Letter of Intent

Application for Approval of Revised Variance of Use

Gateway Trucking

El Paso County PCD File No. - VA256

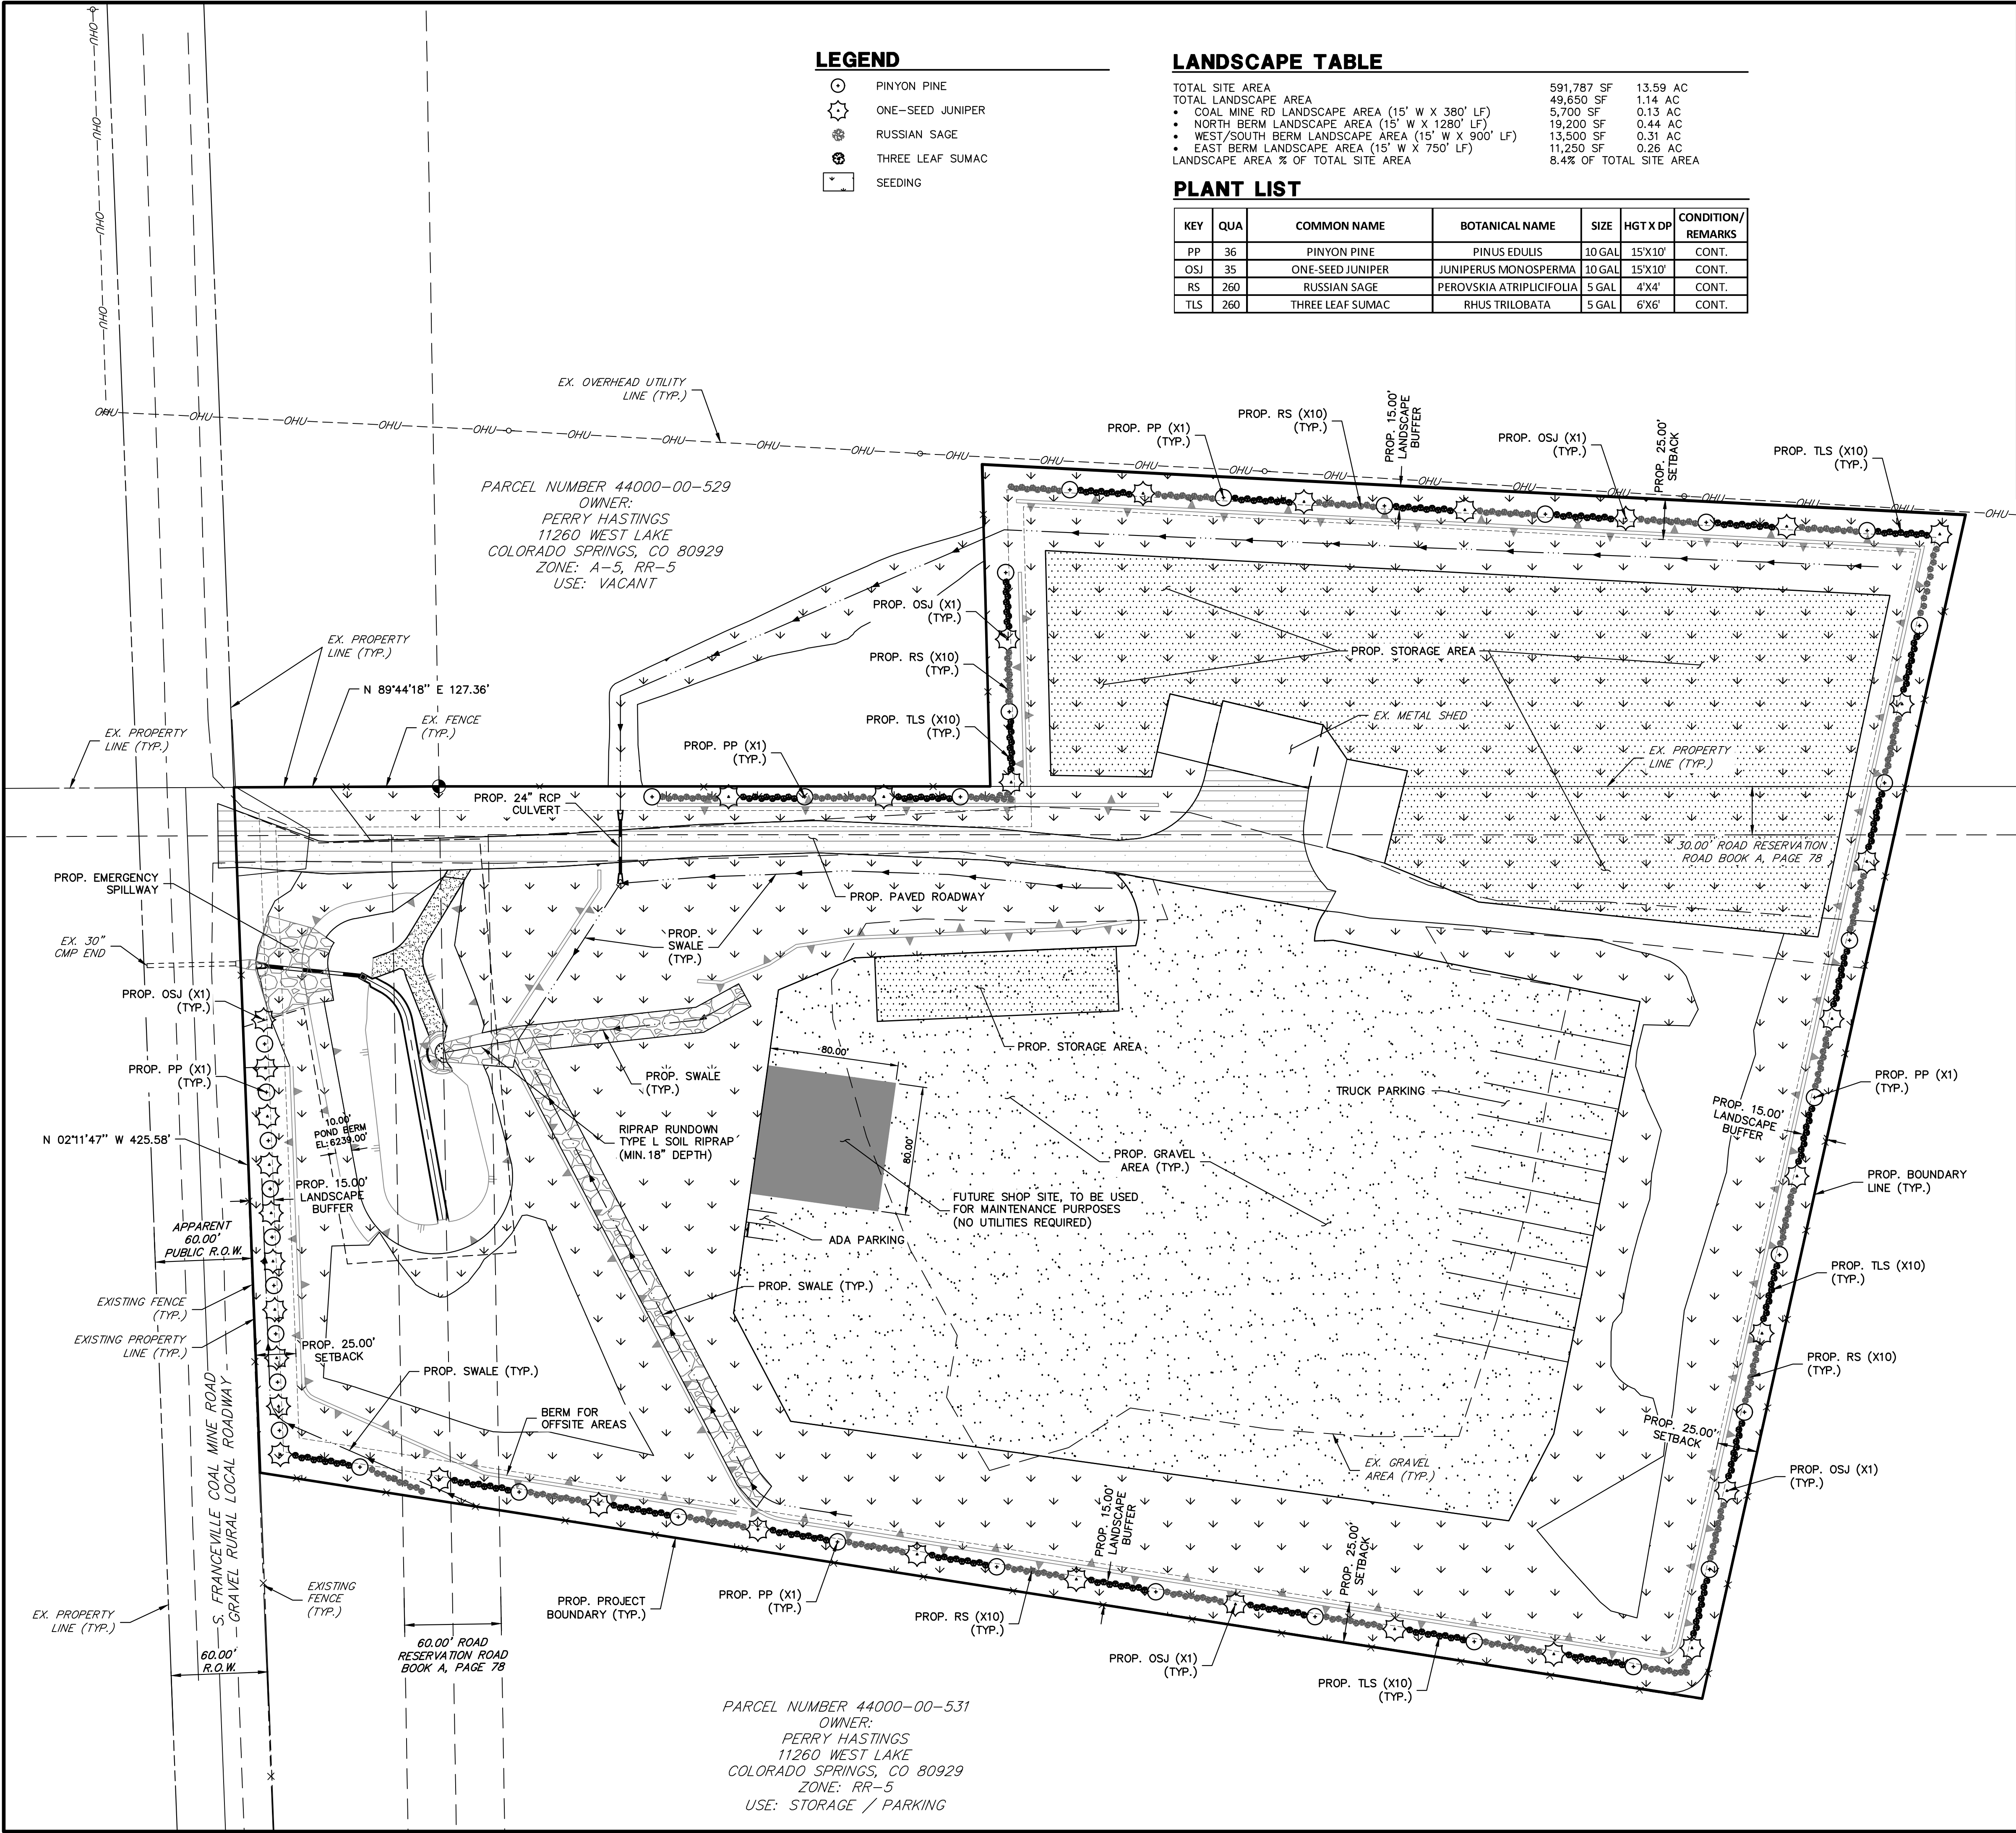
ACTION: You have not addressed the criteria for approval of a Variance of Use. See Code 5.3.4 section on page 7 of this document.

All alternative requests to landscaping, lighting, and parking should remain. Please just add the Variance criteria and your remarks immediately under "V. Criteria..."

JR Response: Addressed
